Planning Consultation Request

Application No.	2022/92406
Proposed Development:	Erection of 10 affordable dwellings, with access from Chapelgate and associated works, including resident play zone
Location:	Land Adj, 67, Chapelgate, Scholes, Holmfirth, HD9 1SX
OS Map Reference	SE 415859.4861 407150.9163
Applicant/Agent:	D5 Planning
Class:	Small Major Developments

**Consultation Response from Mike Hibbert,
KC Waste Strategy(Refuse & Recycling)**

**Erection of 10 affordable dwellings, with access from Chapelgate and associated works,
including resident play zone**

Floor Plan

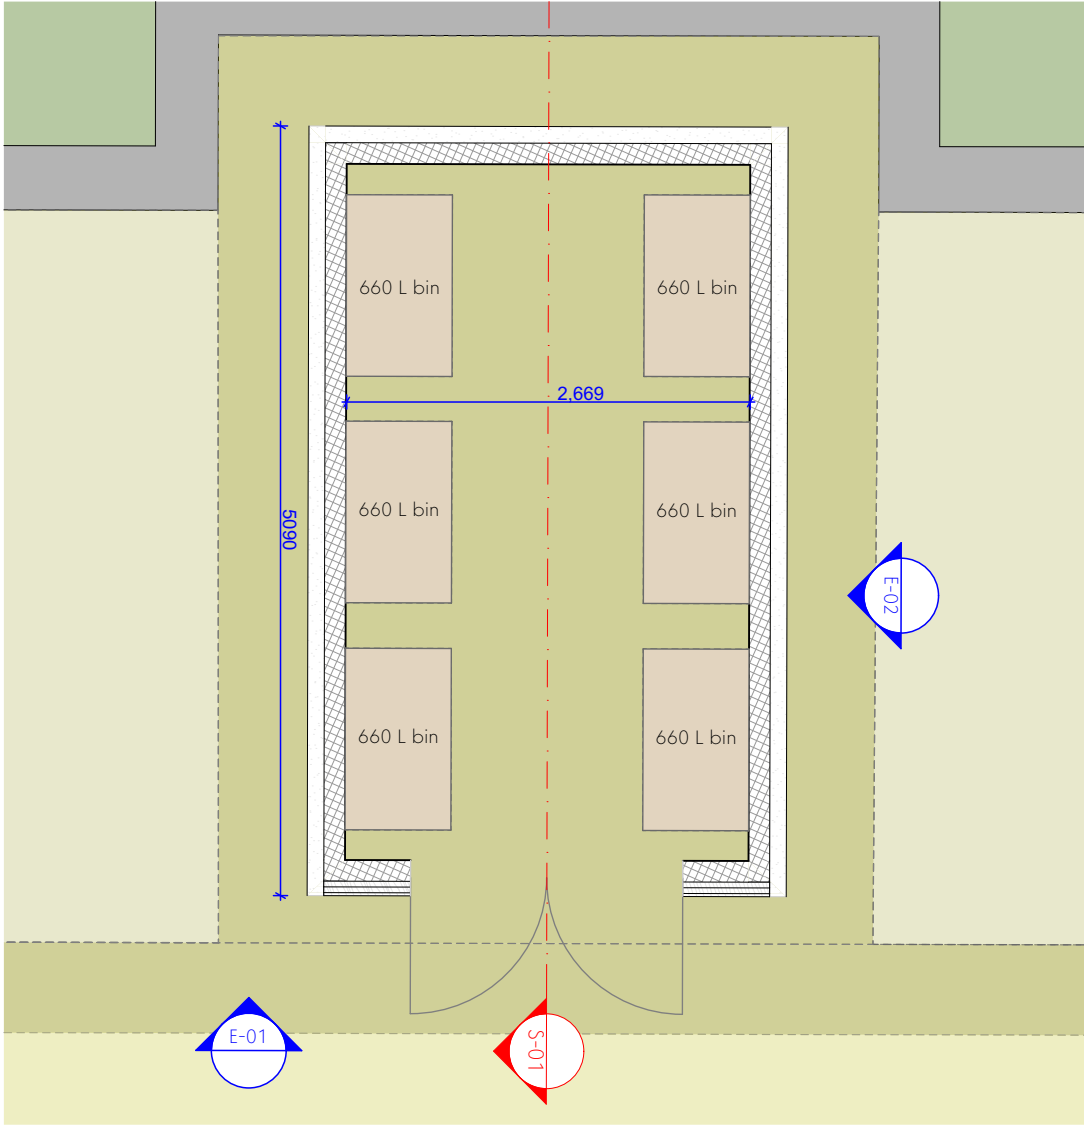
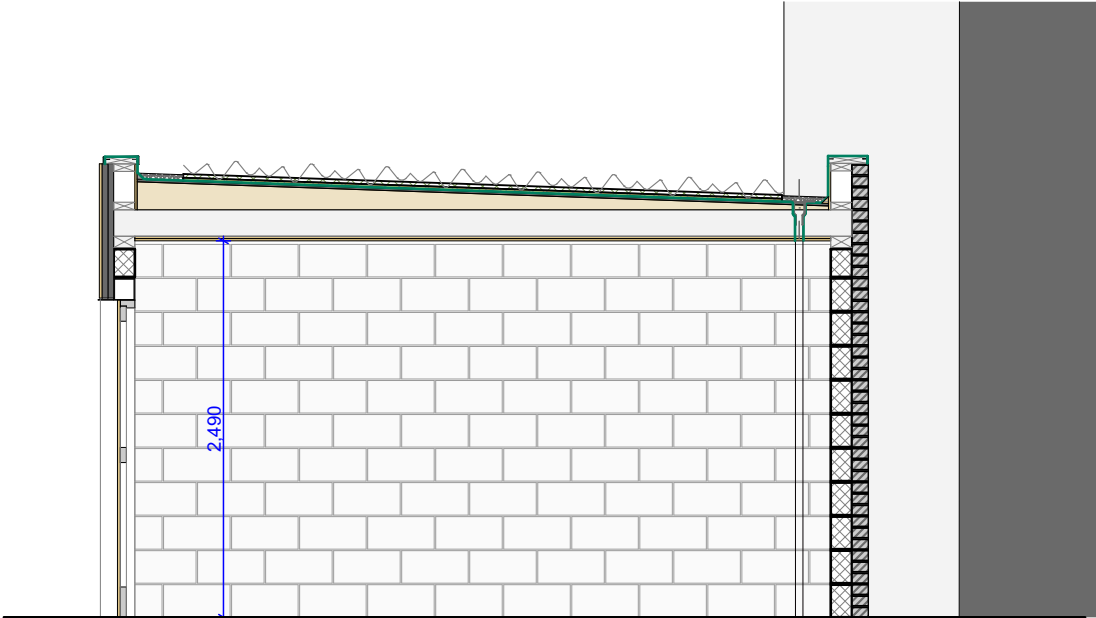
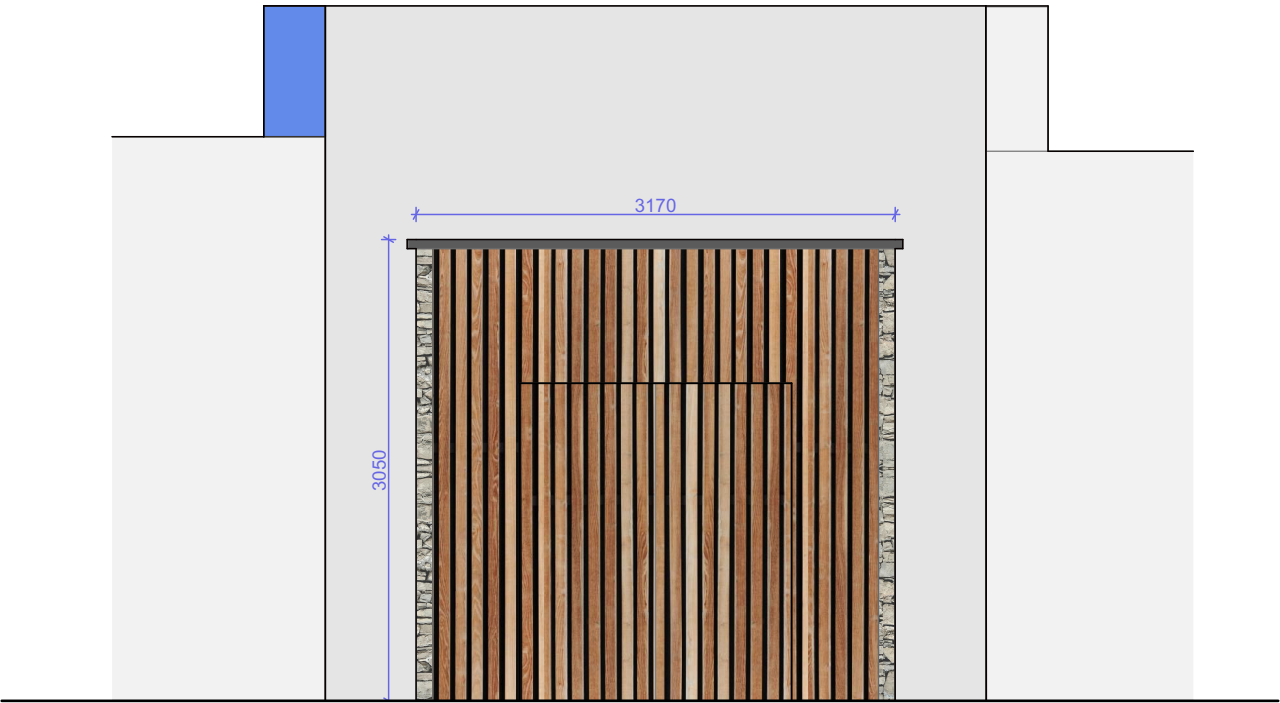
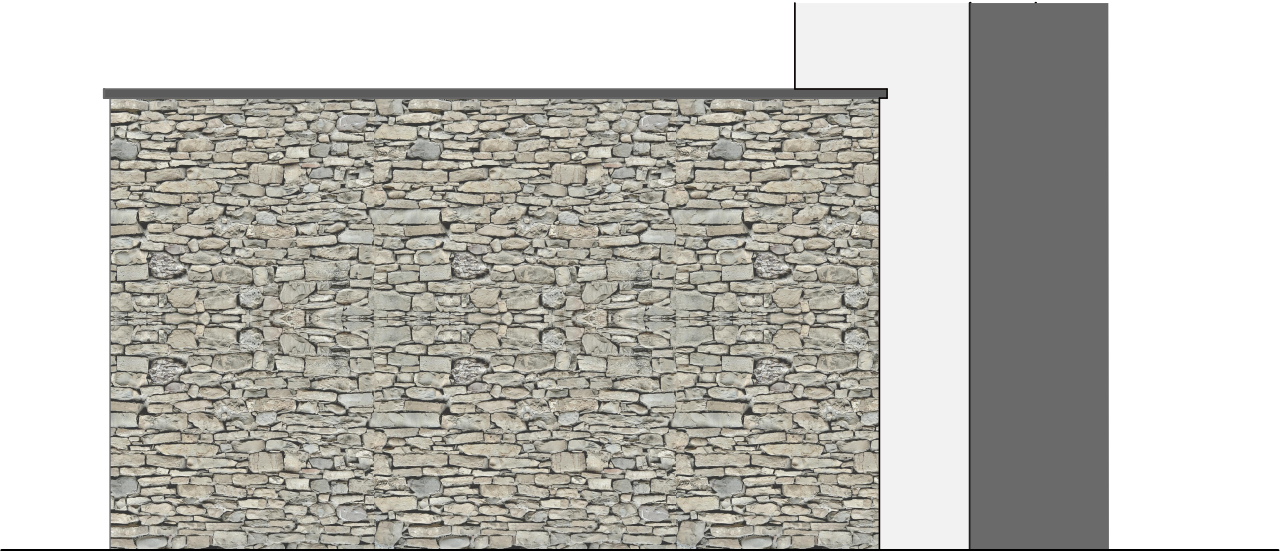
- The location of the communal bin store will provide access to all the residents.
- The construction specification should follow BS5906:2005, Building Regs 2010 Part H6 and CFPA-E Guideline No 7:2022 F.

- The measures to minimise visual impact of the store are excellent.
- The bin store entrance/ aperture at approximately 1800mm is big enough to enable the passage of wheeliebins. If the doors to the bin store are to have a keypad to secure access these details will be required by the collect staff.

- The internal dimensions of the bin store are shown as approximately 2669 mm by 4597mm. Current Wheeliebin sizes are for 660 ltrs 1360x770 (floor space 1560x970) and for 1100ltrs 1375x990 (floor space 1575x1190). On this the basis the internal store will accommodate 6 x 660ltrs bins as illustrated on the plan. The store will just long enough to accommodate 3x 100ltrs bins (4525mm) but could be extended slightly to make the facility future proof for use of 1100 bins or another combination of waste containers.
